June 26, 2025

Re: **Savio Ridge Subdivision at 1600 Arroyo Vista Blvd. NW**  
**Erosion and Sediment Control Plan**  
**Engineer's Stamp Date: 6/18/25 (J08E003B & SWQ-2025-00028)**

James D. Hughes, P.E.  
Principal Engineer, Planning Dept.  
Development and Review Services

Drawn By: M. VALLEJOS, CPESC, CISEC	06/18/2025
	<b>ESC-2</b>

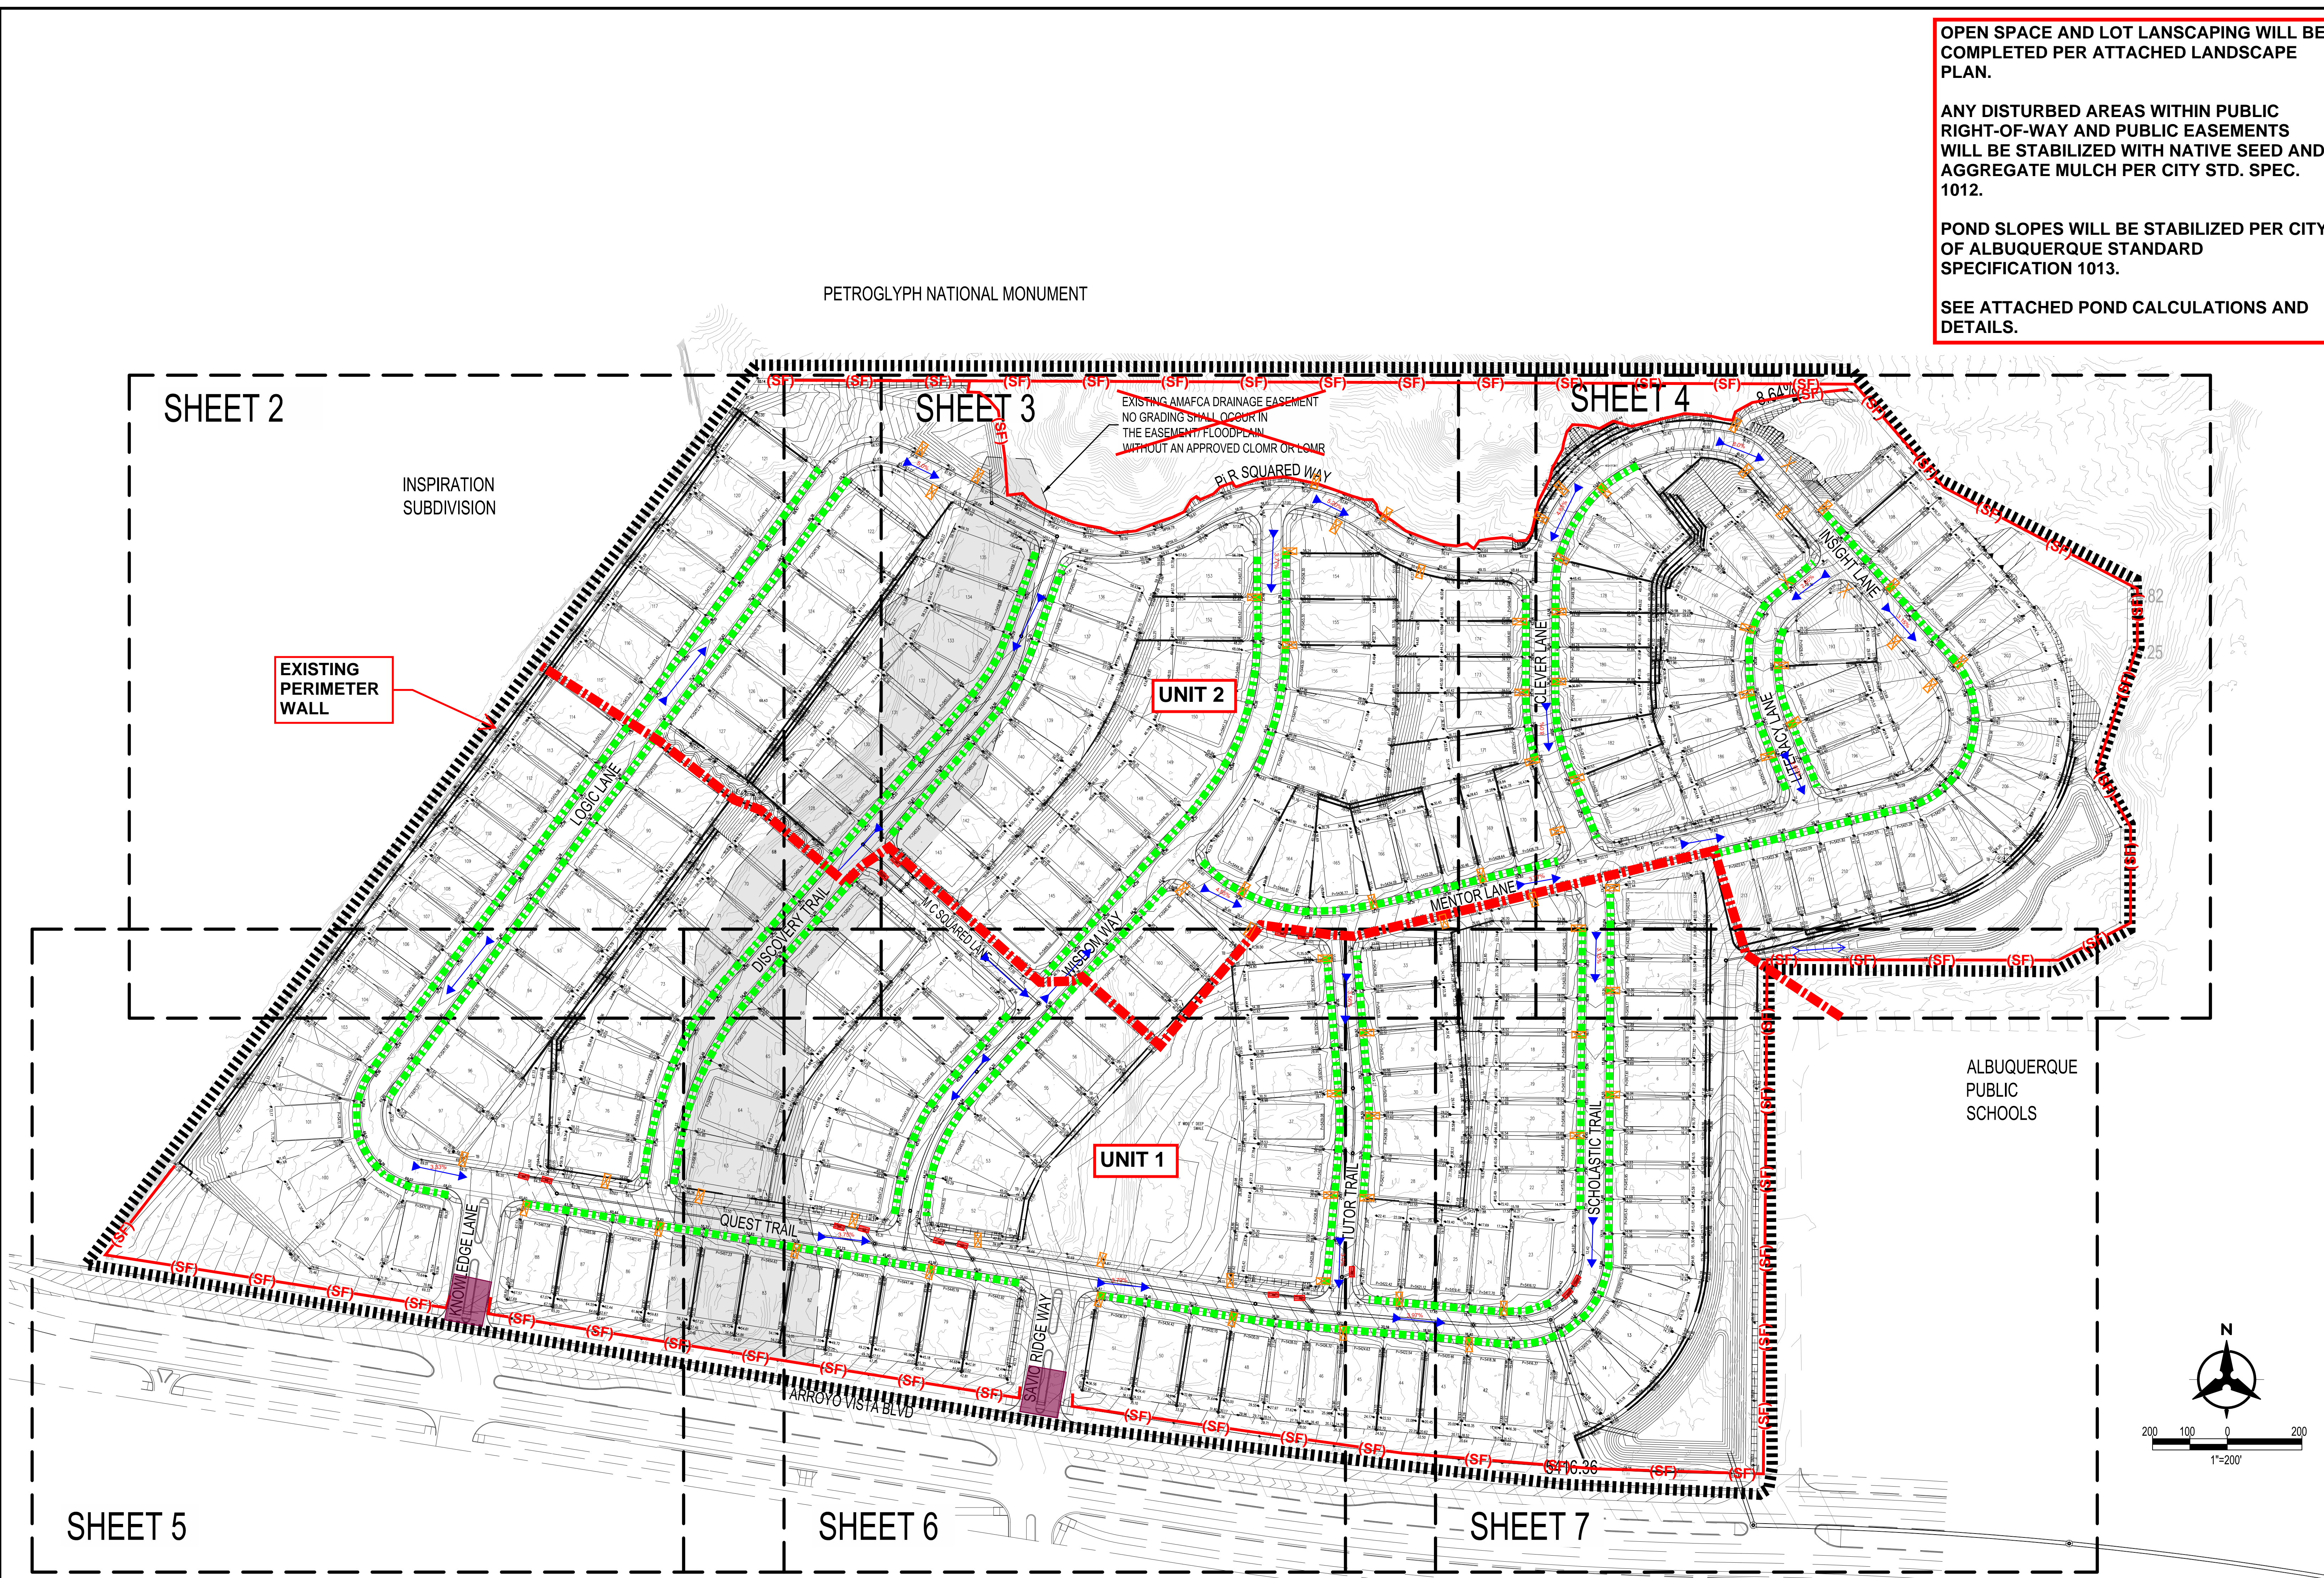
1. The timing of the transition of the downstream ponds (#1 & #2) from temporary sediment traps to permanent first flush and detention ponds needs to be changed on sheet ESC 1 to "after the onsite streets and other BMPs are constructed and before the first house is occupied.

ESC POND VOLUME EXHIBIT

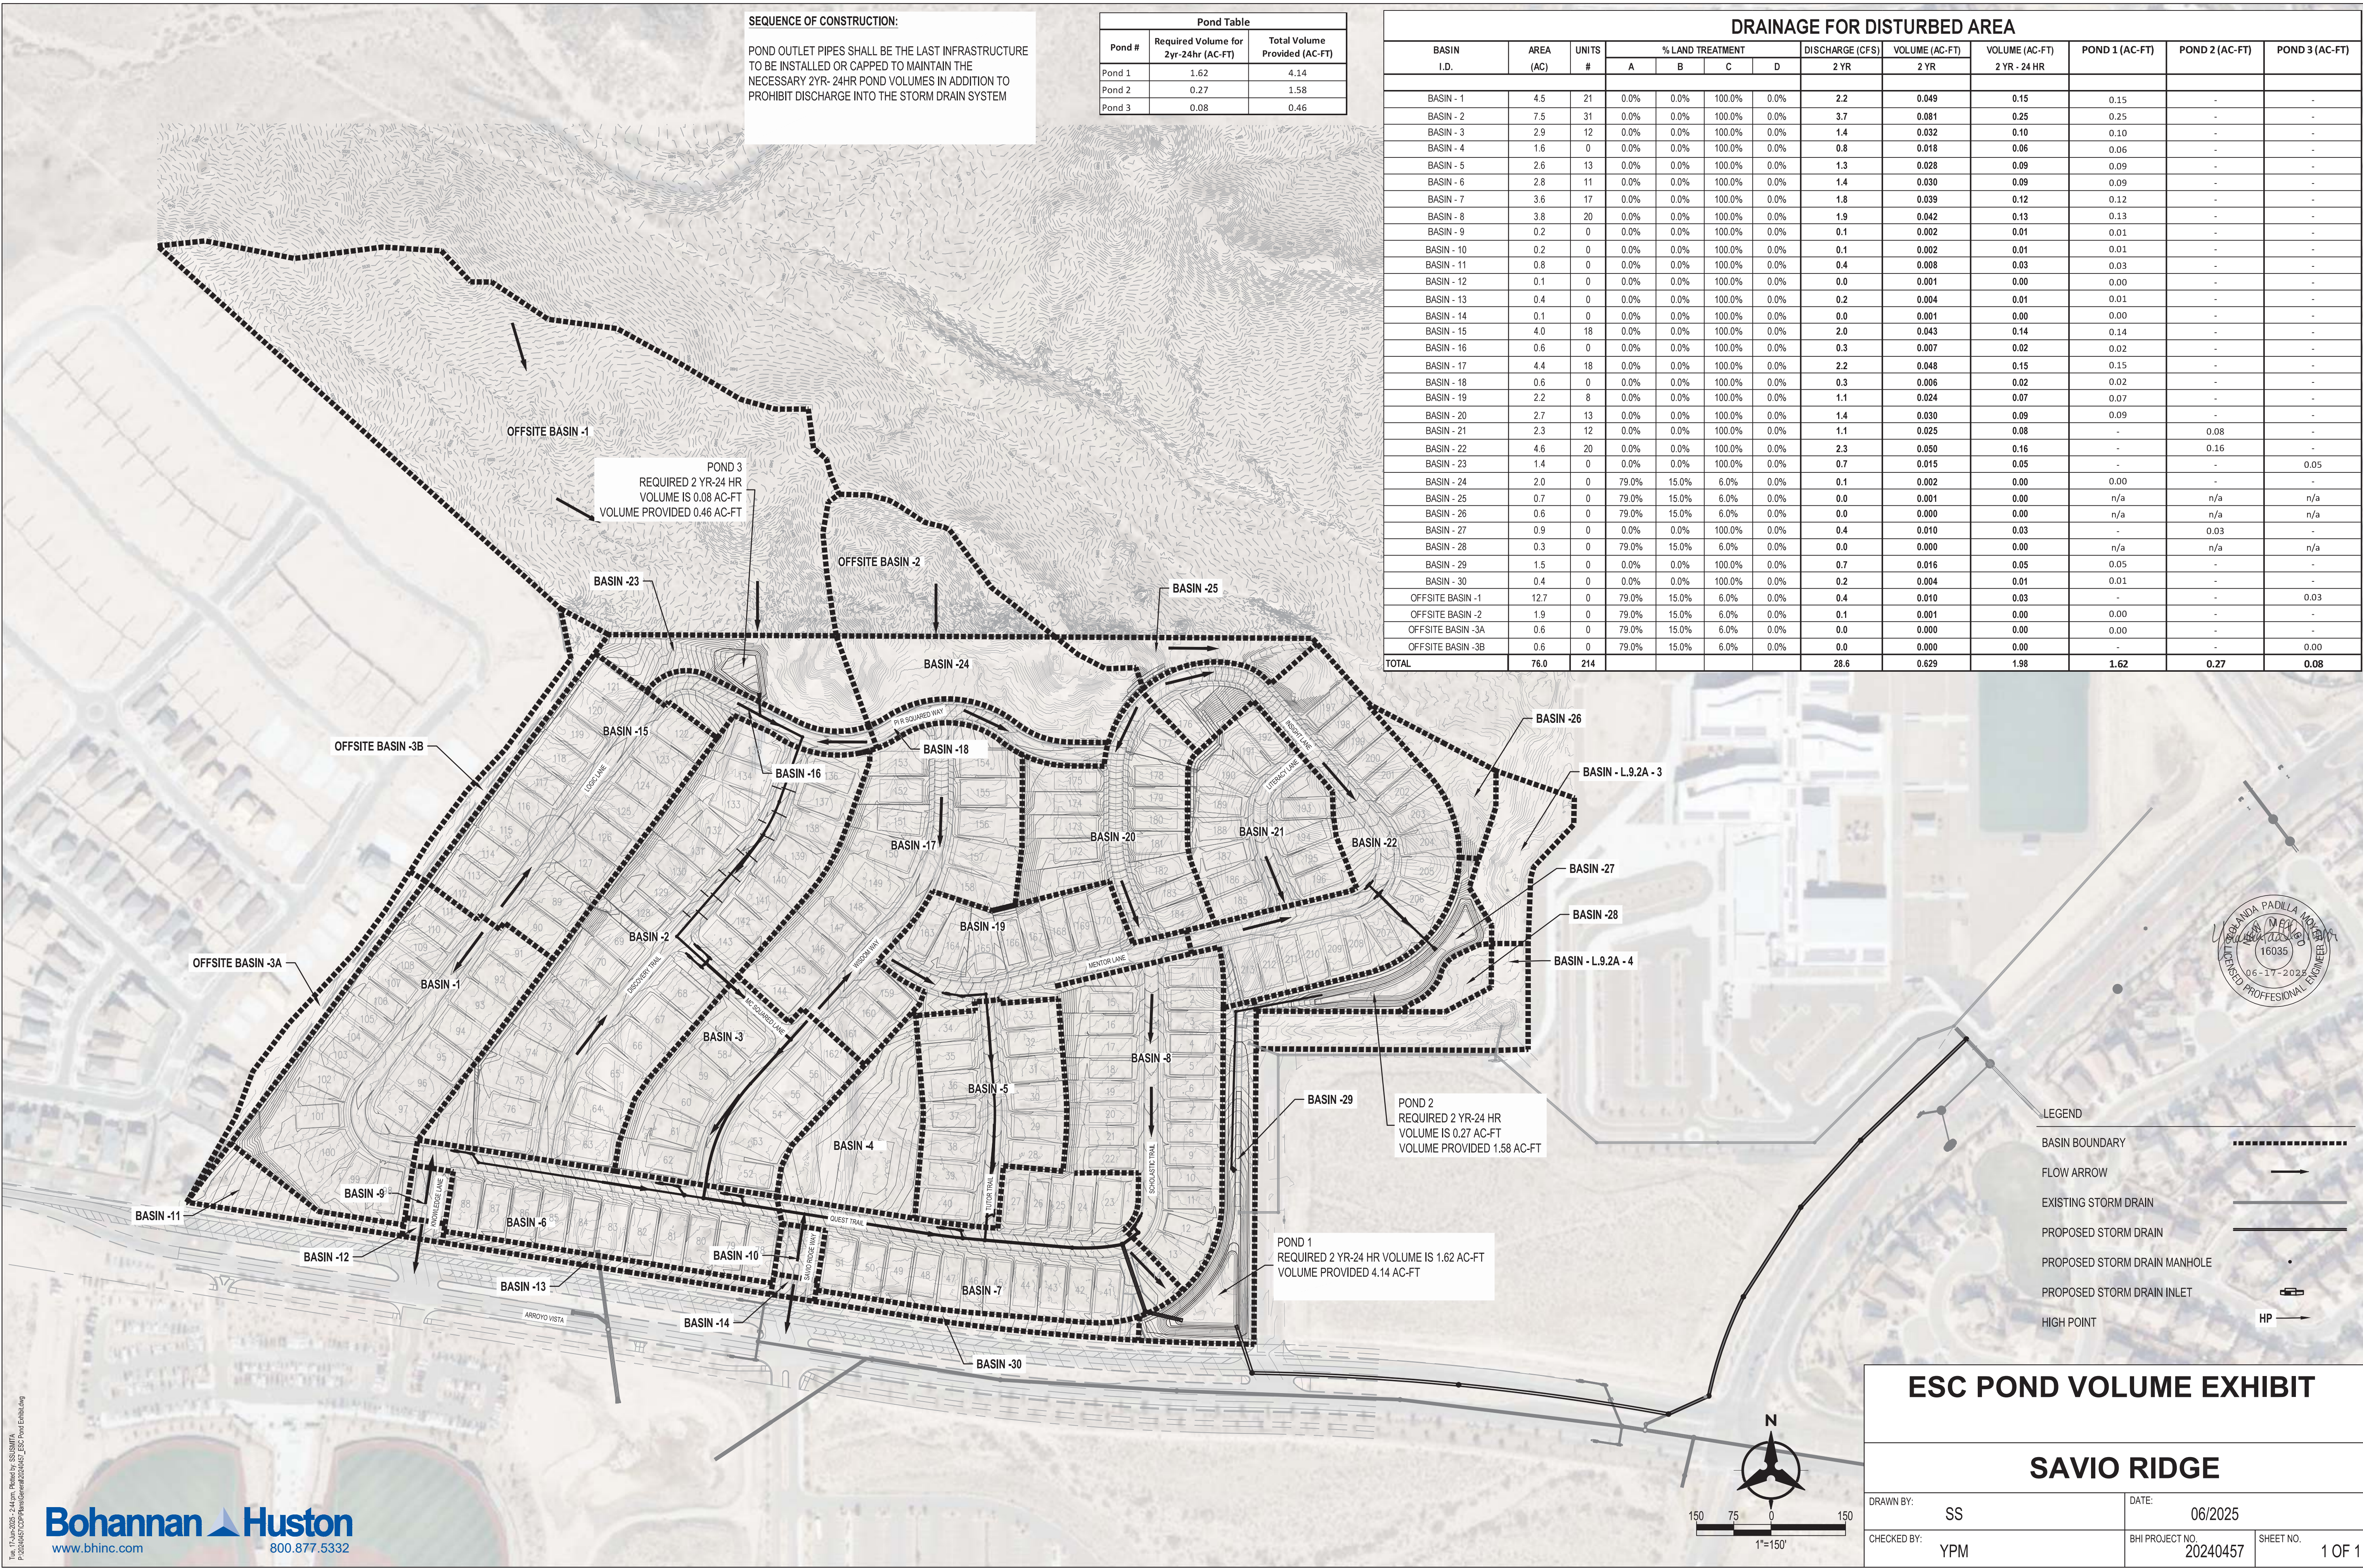
2. The downstream temporary ponds need to be sized to retain the 100-year stormwater runoff until the permanent pond outfall structures are constructed and the above-mentioned transition occurs. Design calculations and construction specifications need to be in the ESC Plans with an updated engineer's stamp. Temporary diversion berms along the downstream perimeter and ponds 1, 2, and 3 need to be the first items of construction before clearing mass grading of the rest of the site commences.

3. Upstream temporary sediment traps need to be sized for the two-year volume at each location where concentrated discharge from future streets enters the Unit 1 streets. Design calculations and construction specifications need to be in the ESC Plans. These temporary sediment traps should be constructed at the same time as the other BMPs after the onsite streets are constructed and before the first house is occupied.
